**MODIFICATION REQUEST:
61 Mobbs Lane, Epping (Former Channel 7
Site)
(MP 10_0107 MOD 1)**

Director-General's
Environmental Assessment Report
Section 75W of the
Environmental Planning and Assessment Act 1979

October 2011

B1 Sections (A1006-A) Rev A

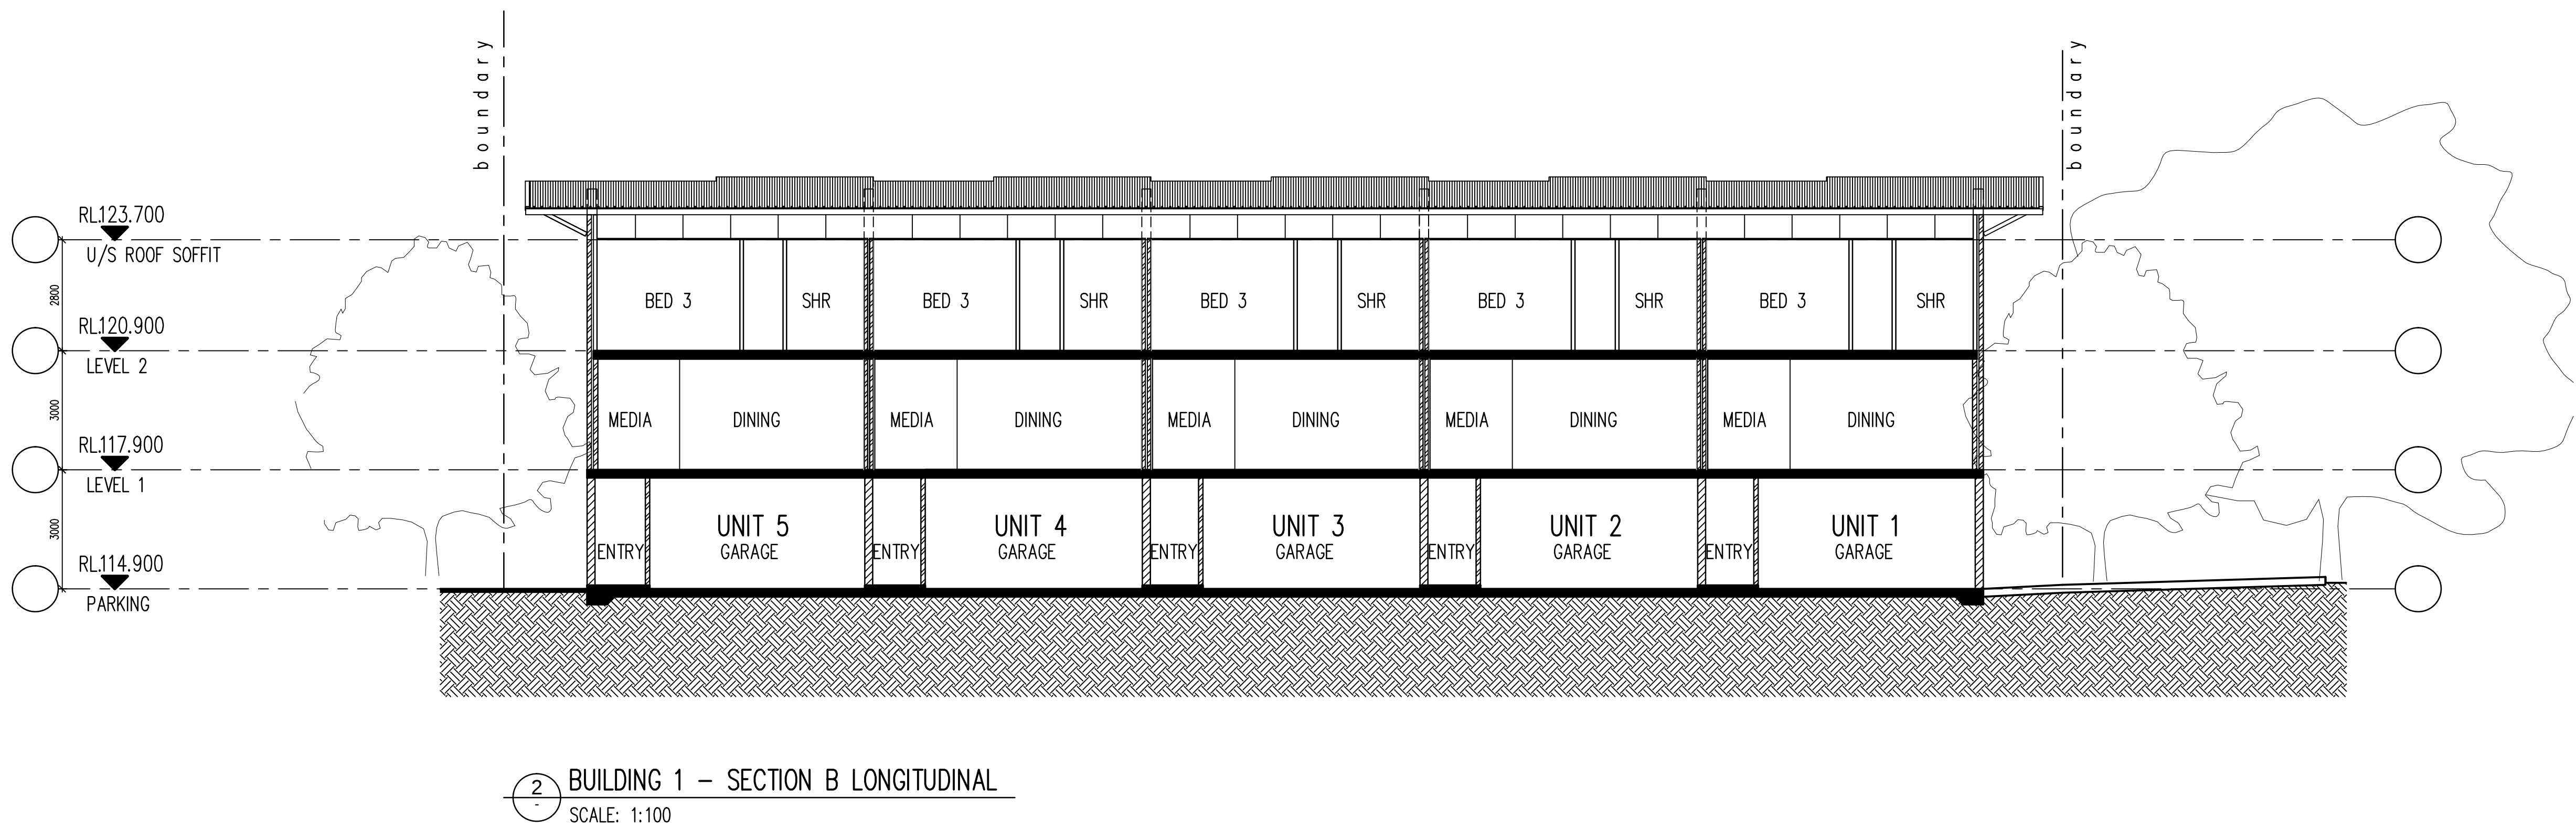
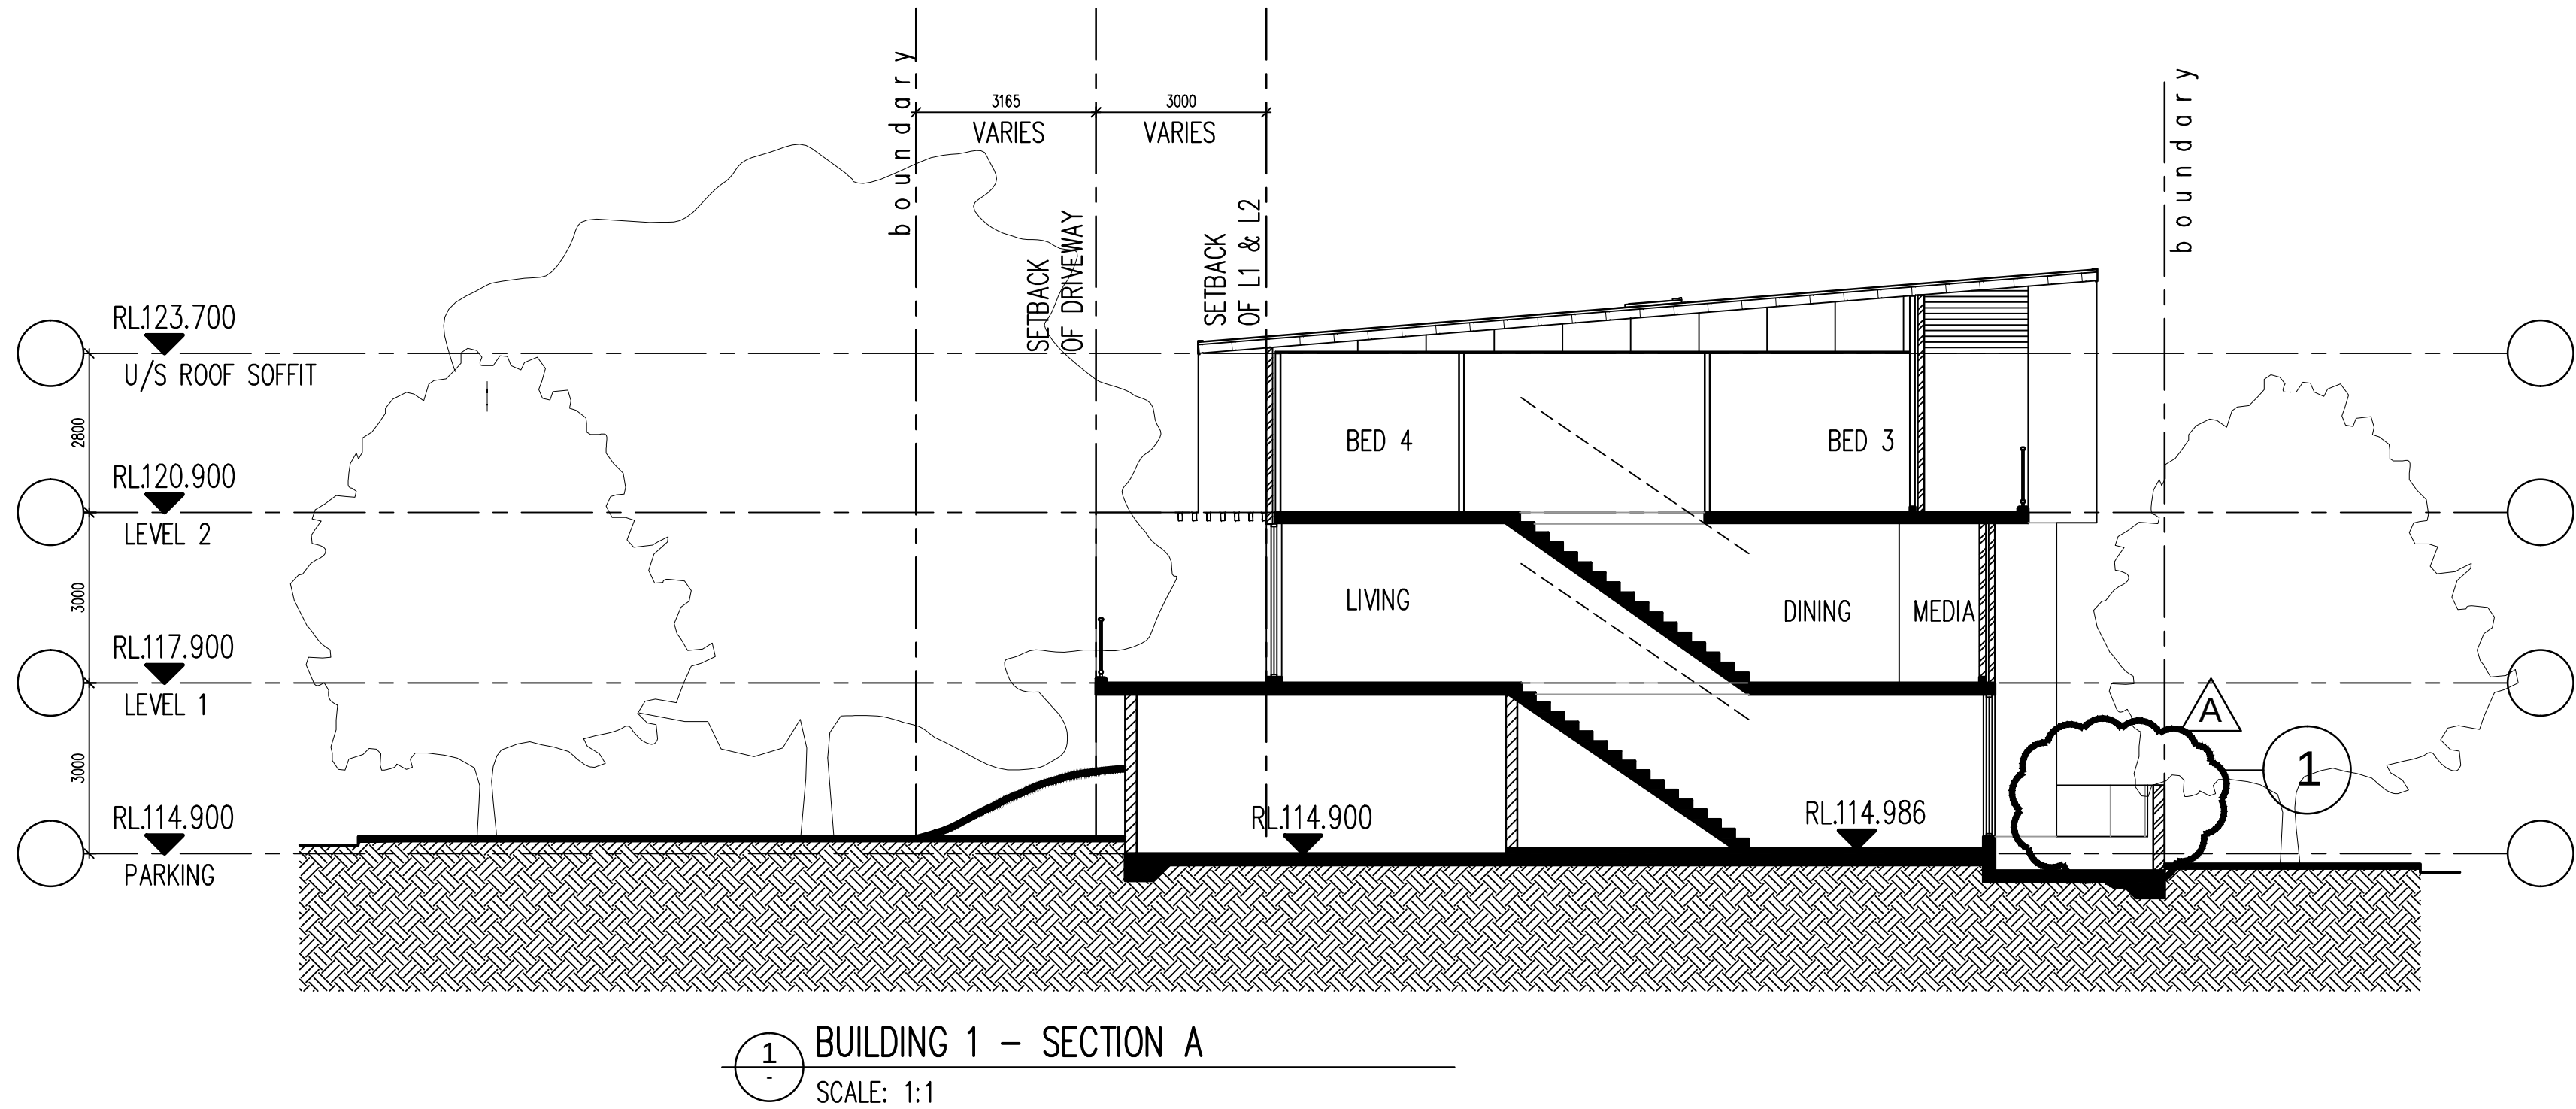
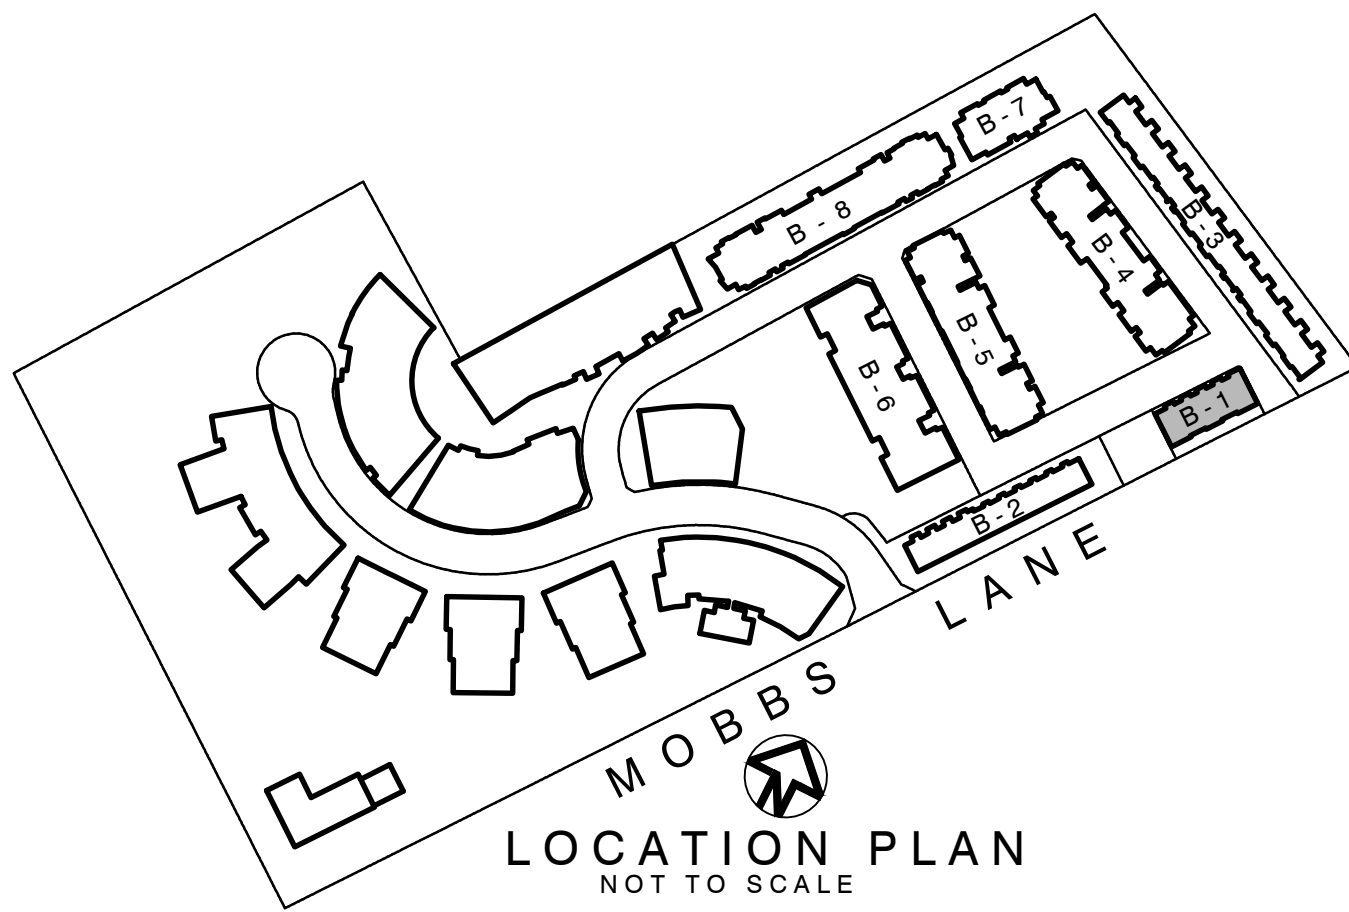
<i>B1 Sections (A1006-A) Rev A</i>	<ul style="list-style-type: none"> new glass and masonry courtyard fence 1.8 m
Building 2 Modifications	
<i>B2 Lower Parking Level (A-1002) Rev A</i>	<ul style="list-style-type: none"> changes in RLs, units' garages from 105.45-106.500 changed to 105.55-106.30 change in RLs on ramp and on driveway, from 105.45 to 105.550-106.30
<i>B2 Parking Level (A1002-B) Rev A</i>	<ul style="list-style-type: none"> change in RLs on ramp and driveway, from 114.00-112.8 to 113.700-112.625 change in RL to apartments from 112.800-110.050 to 112.625-110.825 units 13-16 new sliding doors reconfiguration of kitchen, WC and laundry swap dining room and living room new terraced landscape area new apartment entries
<i>B2 Level 1 Plan (A1003-C) Rev A</i>	<ul style="list-style-type: none"> units 13-16 reconfiguration of internal walls for additional bedroom by removing bedroom 2's ensuite, replacing it with bedroom 4, extending its internal walls and reducing the landing/lounge area by 1.2 m reduction bedroom 2's storage area addition of separate shower area, reconfiguration of existing shared toilet/bath by reduction of bedroom 2's length and extending into landing/lounge area units 6-12 new glass and masonry courtyard fence 1.8 m and change in RL units 6-12 reconfiguration of kitchen, WC and laundry units 6-12 swap dining room and living room unit 6 new window new terraced landscape area and entries units 13-16 reconfiguration of internal walls for bedrooms, ensuite and shower units 13-16 conversion of lounge/landing area into fourth bedroom
